Revise to Preliminary/Final Drainage Report for
Riverbend Crossing Filings No. 1 and 2.

MASTER DEVELOPMENT DRAINAGE REPORT FOR RIVERBEND CROSSING AND FINAL DRAINAGE REPORT FOR RIVERBEND CROSSING FILINGS NO. 1 AND 2

SEPTEMBER 2018

EXISTING DRAINAGE CONDITONS MAP

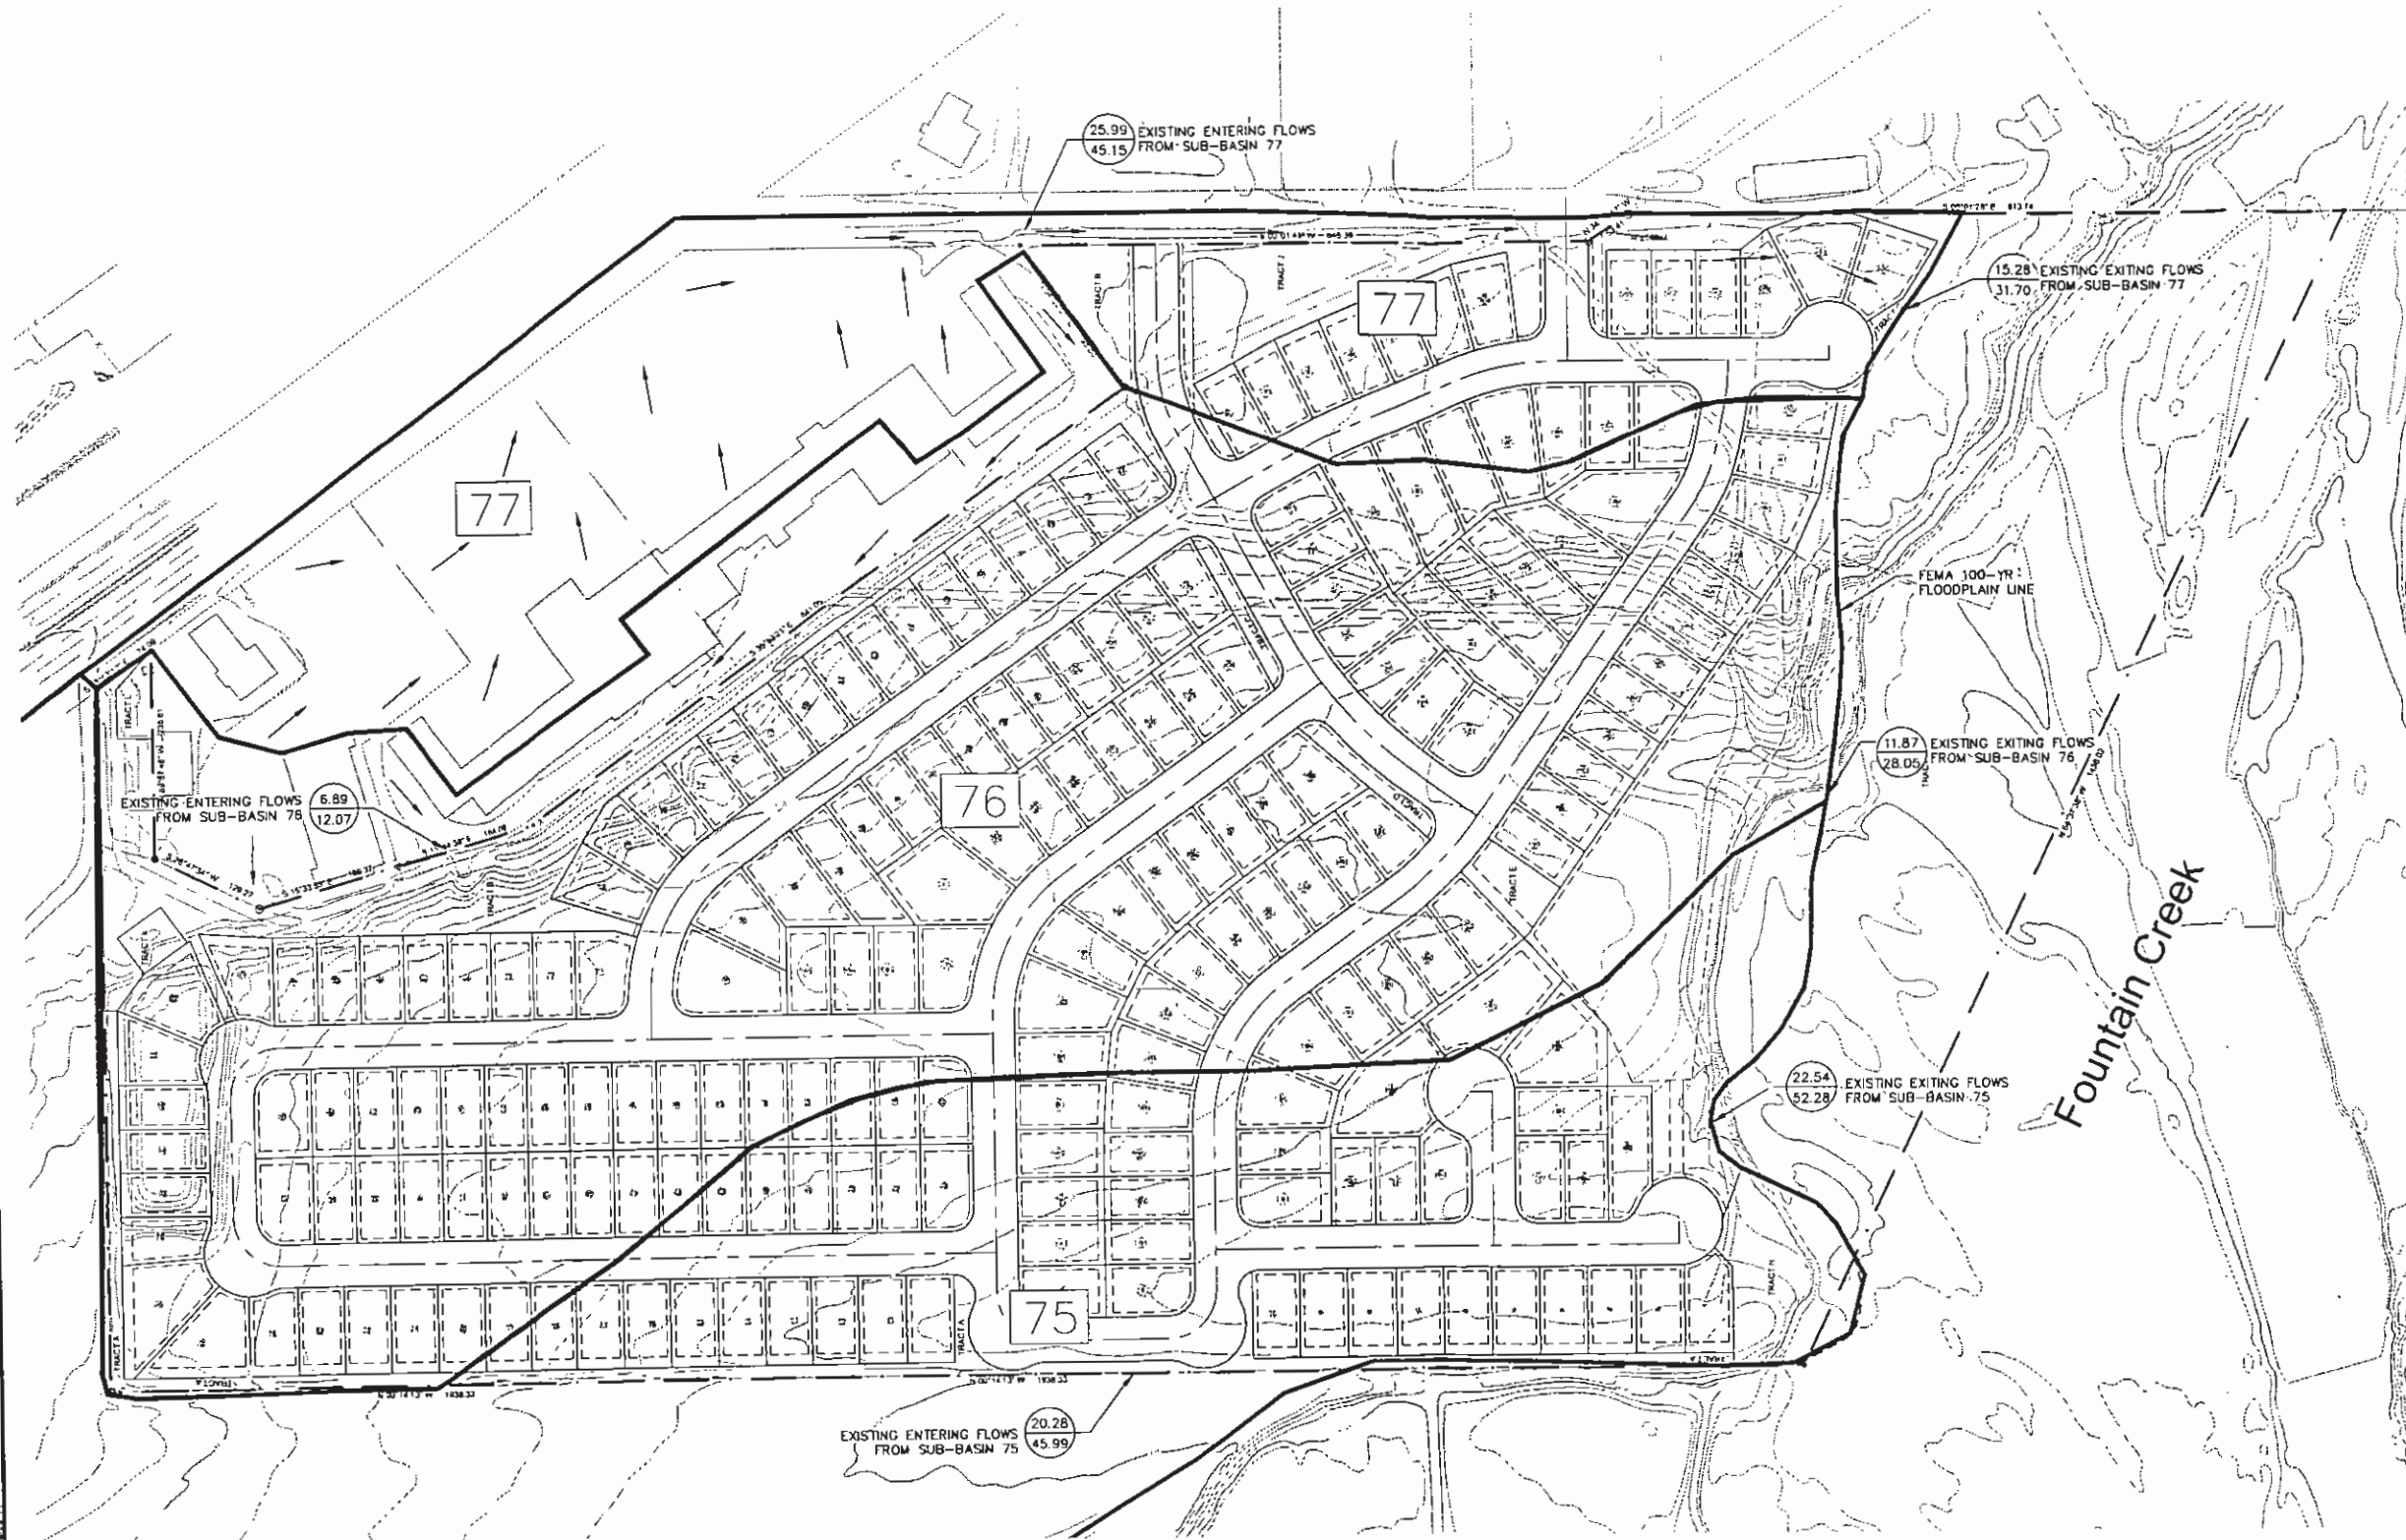
State whether or not there has been a change in character or topography on the adjacent parcels since the preliminary drainage report. If there are then an updated existing drainage map and analysis will need to be provided.

ADDED DISCUSSION OF ST. DOMINIC.
